**Re: Lot 9 and Lot 358 Morisset Park Road, Morisset Park – Response to Council and DOP Comments**

We provide the following information to address Lake Macquarie City Council's (LMCC) concerns raised in their letter dated 30.01.09. The information provided has taken into account discussions and a subsequent meeting with Council Officers David Pavitt and Greg Fitzpatrick. The information below should be read in conjunction with the attachments and the 'Concept Stormwater Management Plan and Road Design' report produced by Northrop Engineers in April 2008.

STORMWATER DETENTION BASIN PLAN

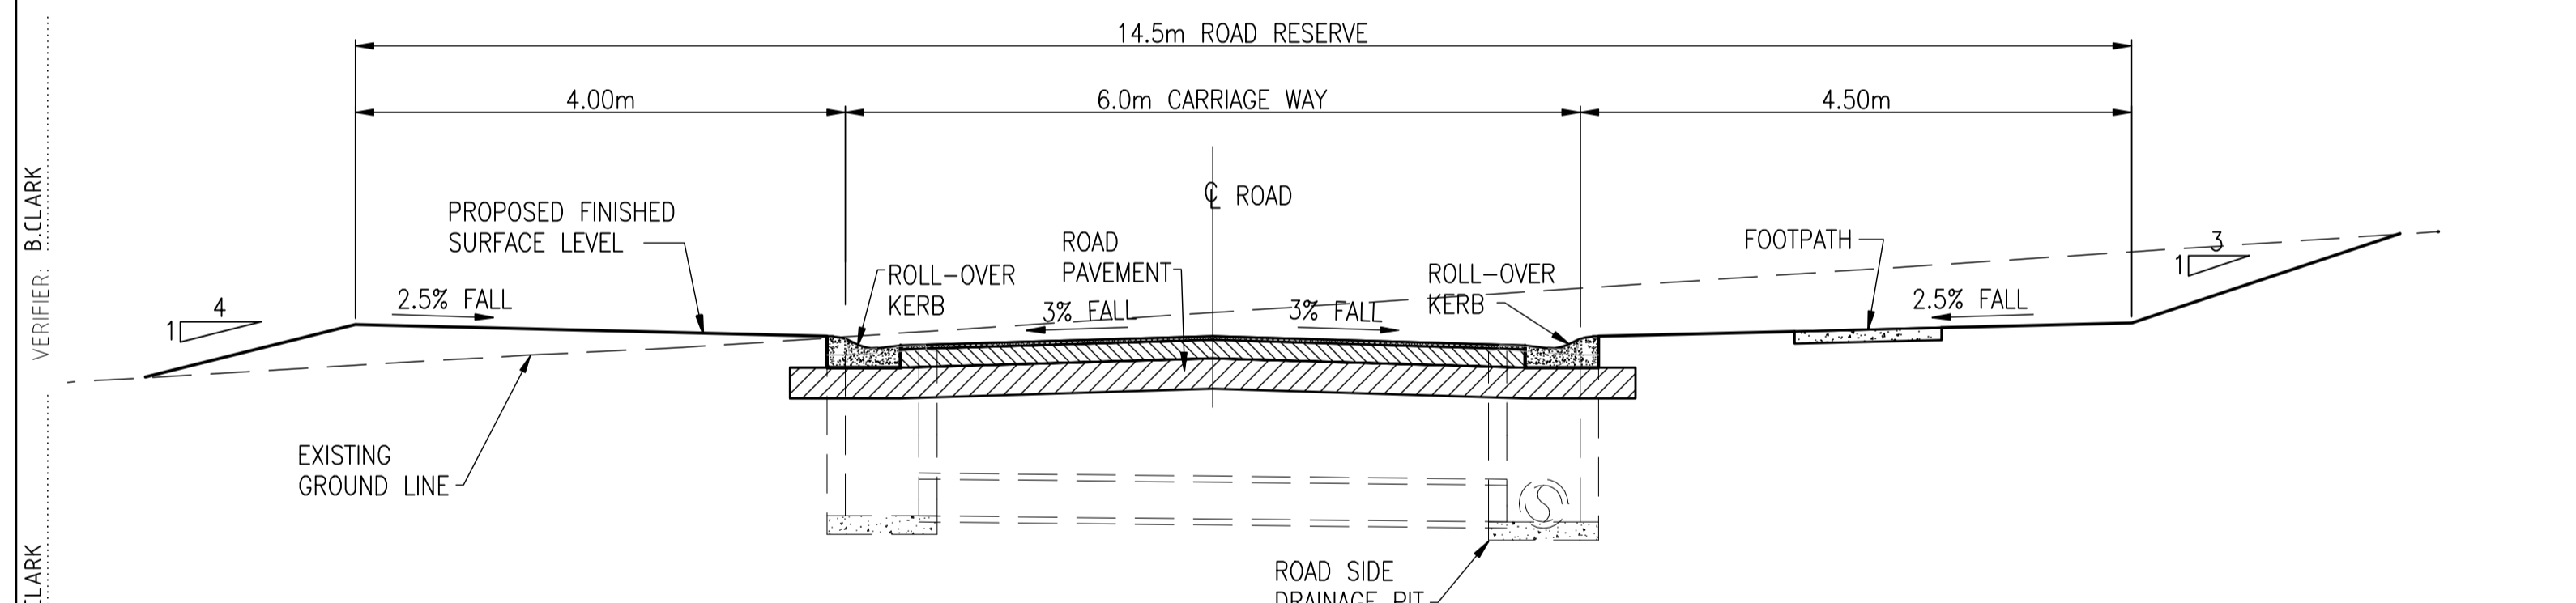
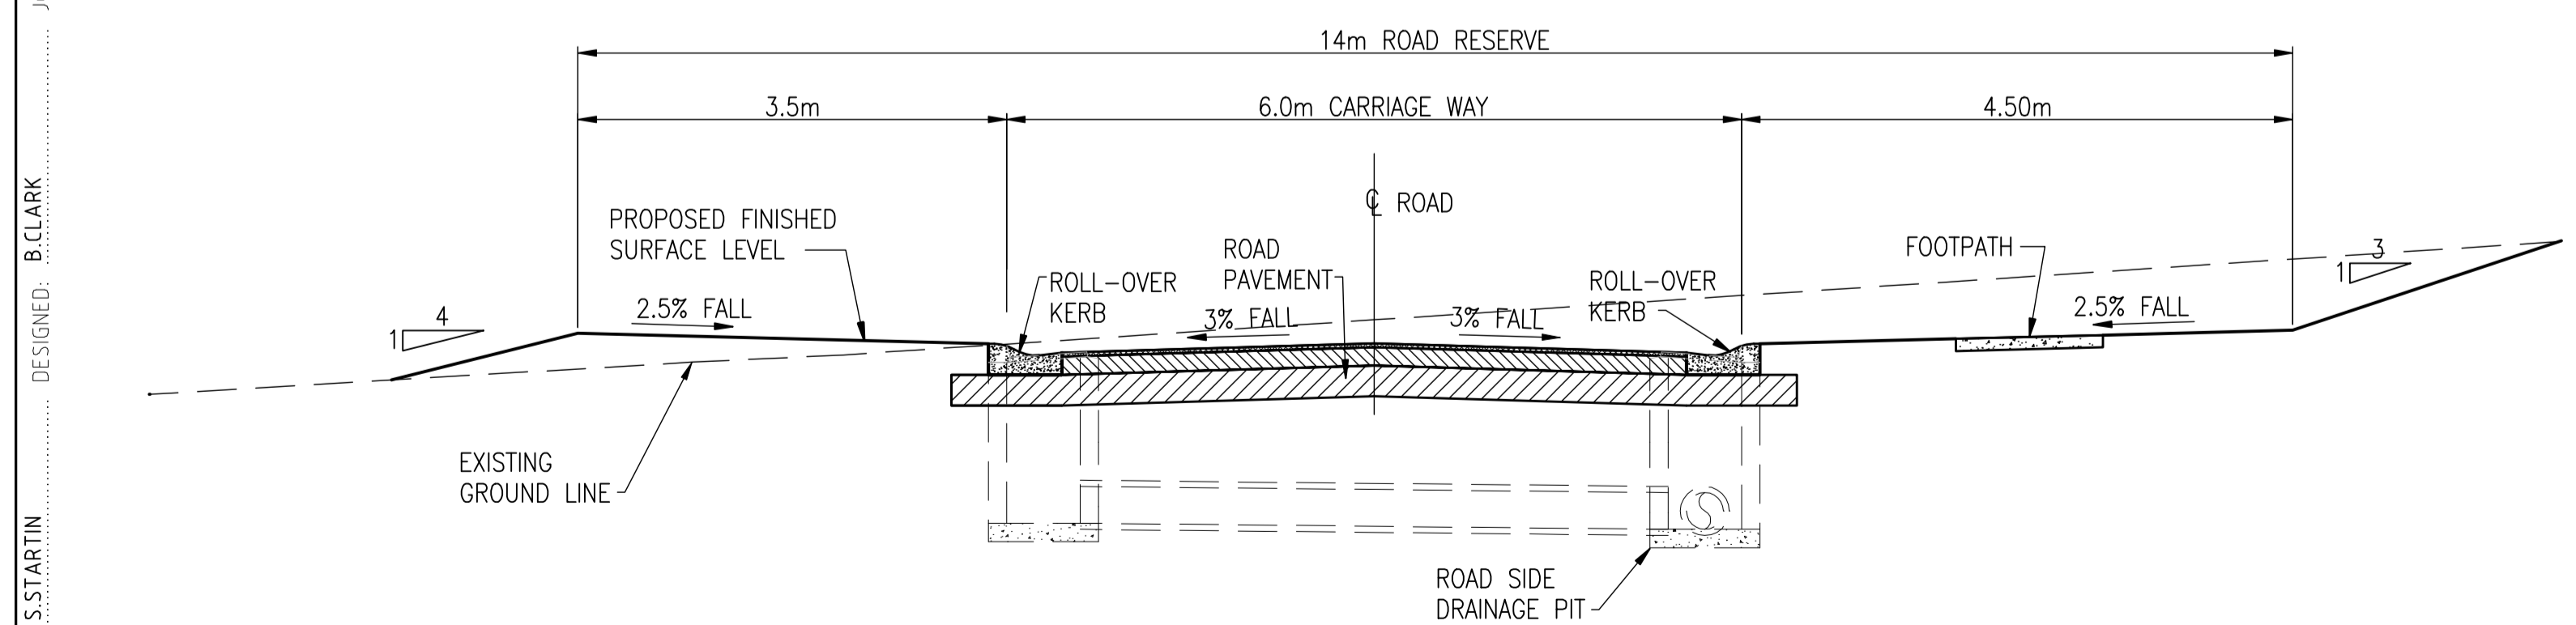
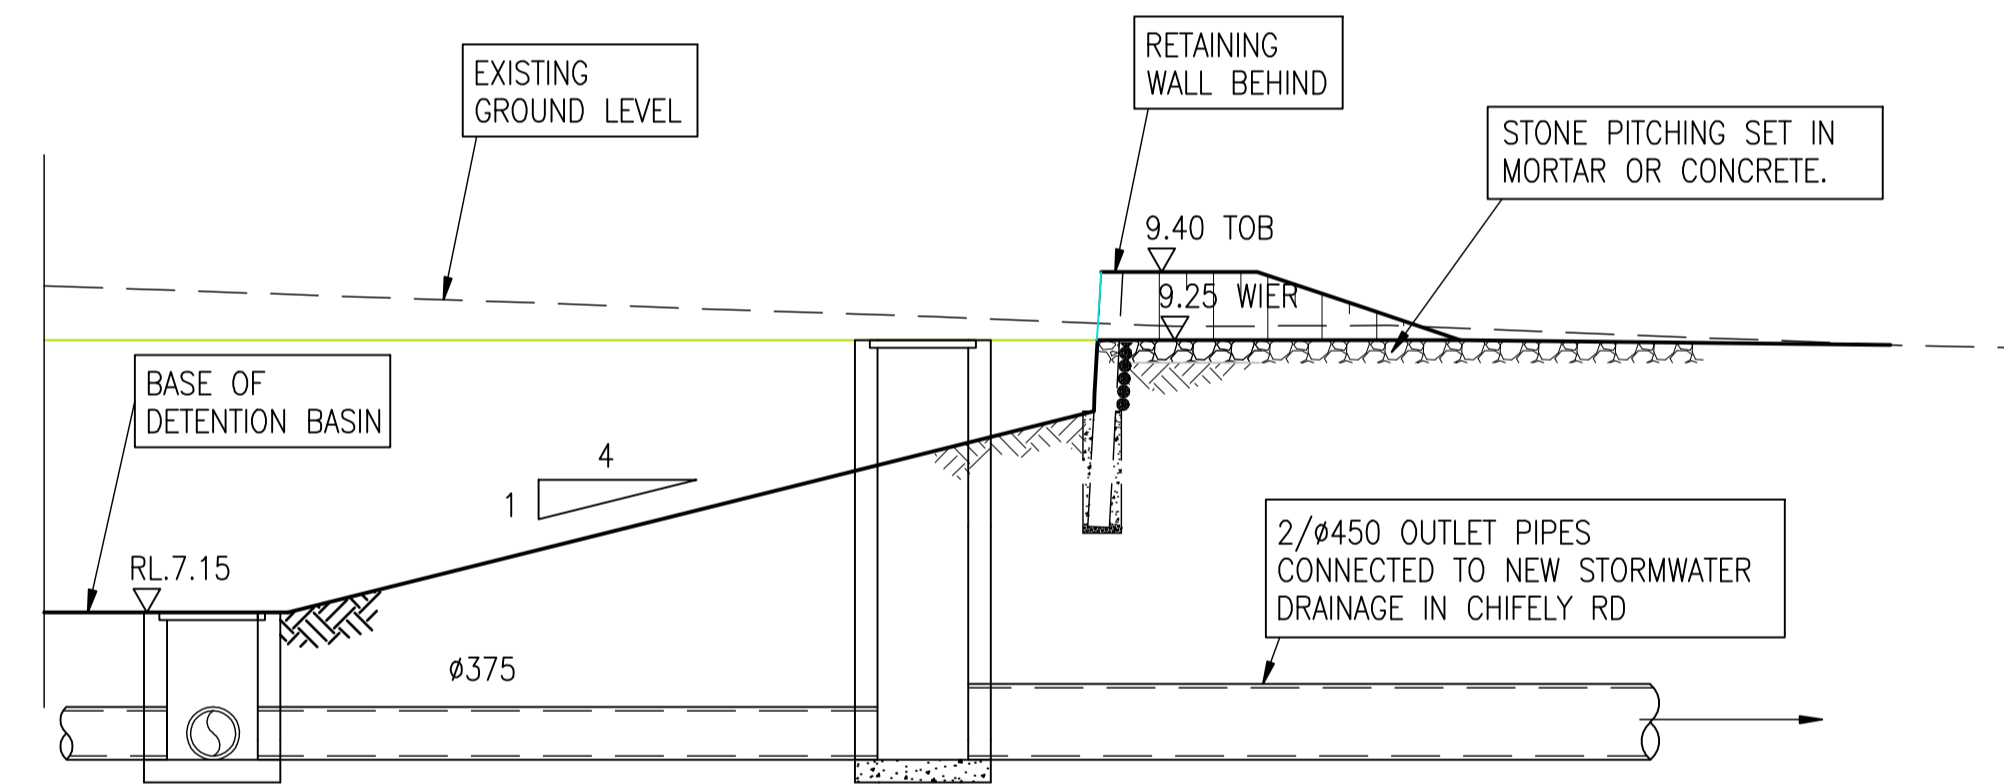
***9. The design of the detention basin shows that the basin will spill in the Q100 ARI event through private property. This is not desirable. Preferably the outflow pipe(s) from the basin would cater for the Q100 ARI flow out of the basin.***

***I note that the pipes that discharge from the basin are proposed to be 300mm in diameter. Council's Engineering Guidelines require that all public pipelines be a minimum of 375mm diameter.***

**11. The internal batters within the basin are proposed to be as steep as 1V:3H. Council's maintenance requirements are such that any grassed batters should be no steeper than 1V:4H.**

***15. The current design of the detention basin has pipes discharging into the base of the facility. These flows then exit via the outflow headwall. This design means that the base of the basin would be often affected by trickle flows and can become muddy and unsightly and difficult to maintain. The aesthetics of the facility also suffer due to the presence of the headwalls. An alternate design that can be considered is to have the flows contained within pipes under the basin with storms surcharging up into the basin via surcharge grates.***

The outlet from the basin has been redesigned to incorporate Council's comment where possible. At the weir level a large pit has now been designed to take high level flows previously directed to the weir. This pit will be located downstream of the low flow orifice (refer amended drawings in Attachment 1).

The internal batters on the basin have been revised to be a maximum of 1V:4H. The new stage storage relationship has been gained for the basin.

1. New Stage / Storage relationship shown above
2. A low flow outlet contained in a pit under the basin instead of a headwall (refer Comment 15)
3. High level pit with cover level at 8.95m AHD to take high level flows
4. 375mm outlet from low flow pit to high flow pit
5. 2 x 450mm pipe outlet from high flow pit to Chifley St

As noted in comment 11 the design of the outlet has incorporated Council's suggestion.
